## Portishead Branch Line (MetroWest Phase 1)

9.1 ExA.Sch.D3.V3 – Schedule of Changes to the draft Development Consent Order

**Log of drafting changes for Deadline 3 draft DCO**

**21 December 2020**

2.47 - Ashton Vale Road and Winterstoke Road Highway Works Plan

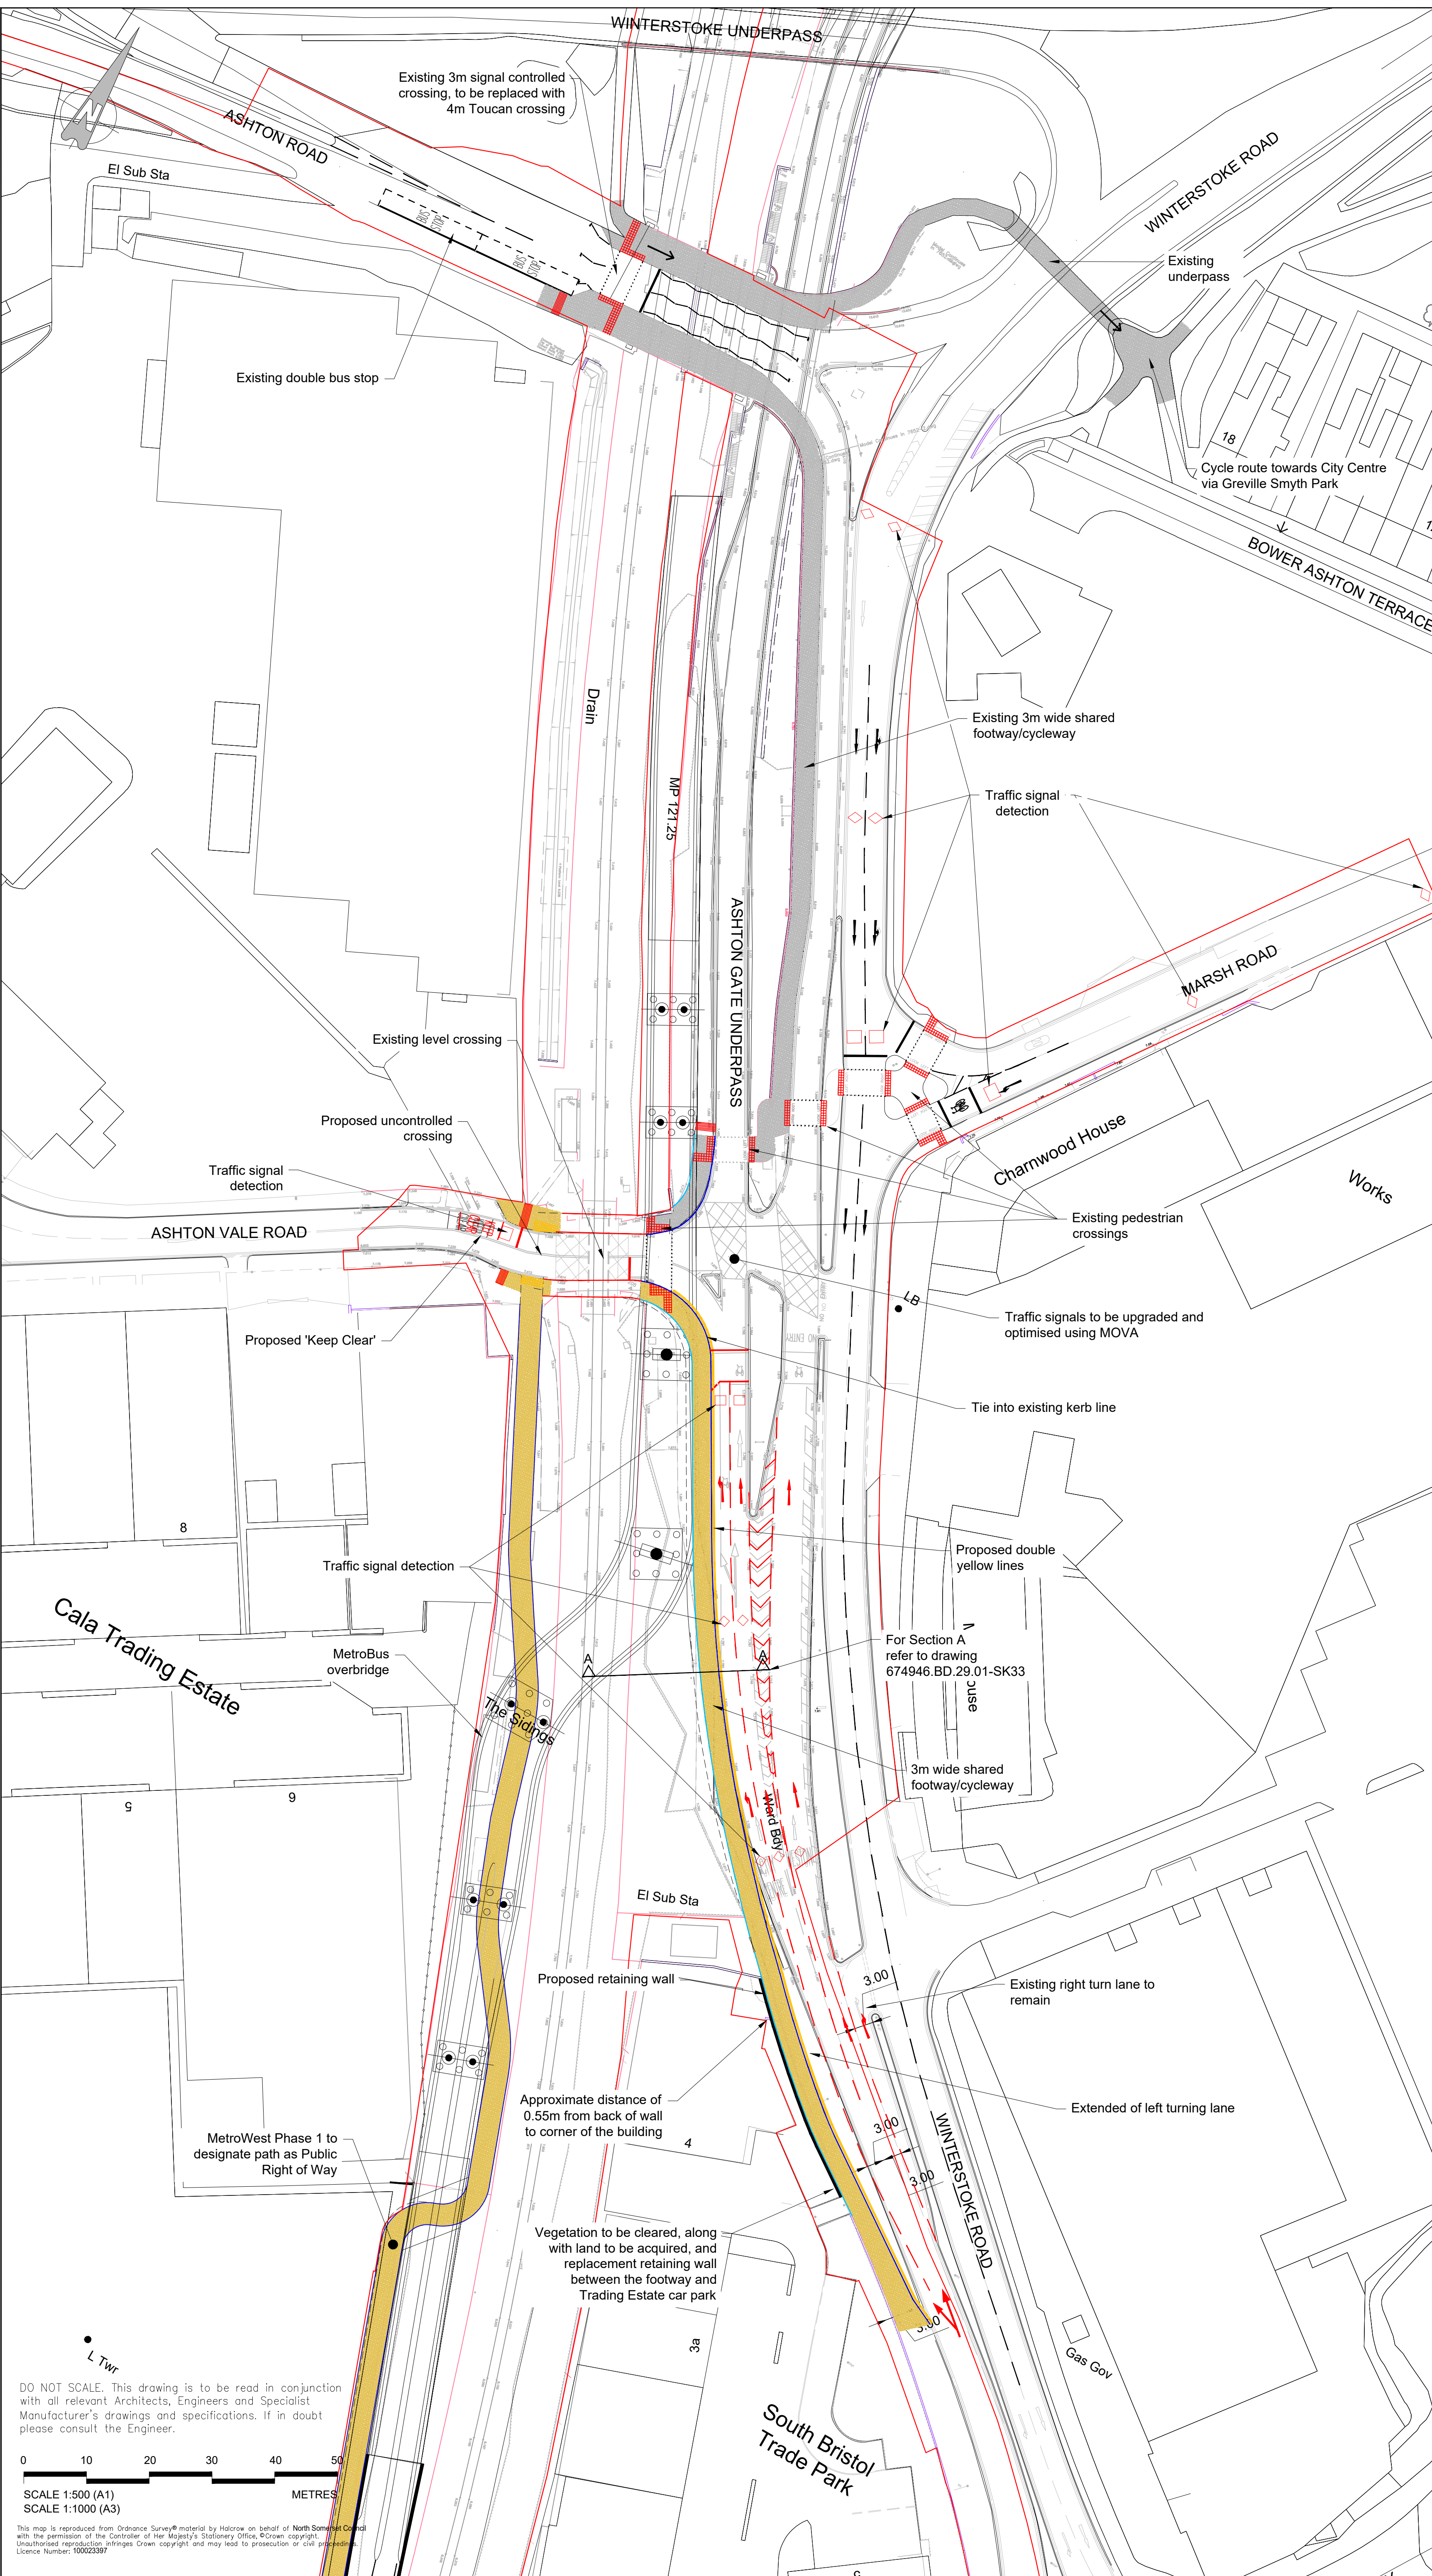
<p>(18).-(1) Work No. 28 (Winterstoke Road and Ashton Vale Road Junction) must not commence until the relevant planning authority, in consultation with the relevant highway authority, has approved the detail design for Work 28, to include—</p> <ul style="list-style-type: none"> <li>(c) an extended left turn lane on Winterstoke Road for vehicles in to Ashton Vale Road; and</li> <li>(d) details for the installation of a MOVA system or other traffic control measures designed to maximise the operational efficiency of the Winterstoke Road and Ashton Vale Road junction including provision for the movement of trains over the level crossing at Ashton Vale Road.</li> </ul> <p>(2) The detail design required by paragraph (1) to be submitted to the relevant planning authority must be in substantial accordance with the Ashton Vale Road and</p>	<p>requirements specific to the relevant work.</p>		
--	--	--	--	--

<p><b>Winterstoke Road Highway Works Plan.</b></p> <p>Work No. 28 must be carried out in accordance with the approved details to the satisfaction of the relevant planning authority in consultation with the relevant highway authority prior to first commercial use.</p>			
Schedule 2, Requirement 20	<p><b>Path at Marsh Lane, Easton in Gordano</b></p> <p>20—(1) Work No. 15 must not commence until written details of the levels and surfacing of the Work have been submitted to and approved by the relevant planning authority in consultation with the relevant highway authority. The Work must be carried out in accordance with the approved details.</p> <p>(2) Following cessation of the construction haul road between Marsh Lane and the compounds located under the M5 Avonmouth Bridge and on Lodway Farm, Work No. 15 must be removed as within 6 months to the satisfaction of the relevant planning authority in consultation with the</p>	More precise timetable for compliance provided as the suggestion of the ExA.	-	-
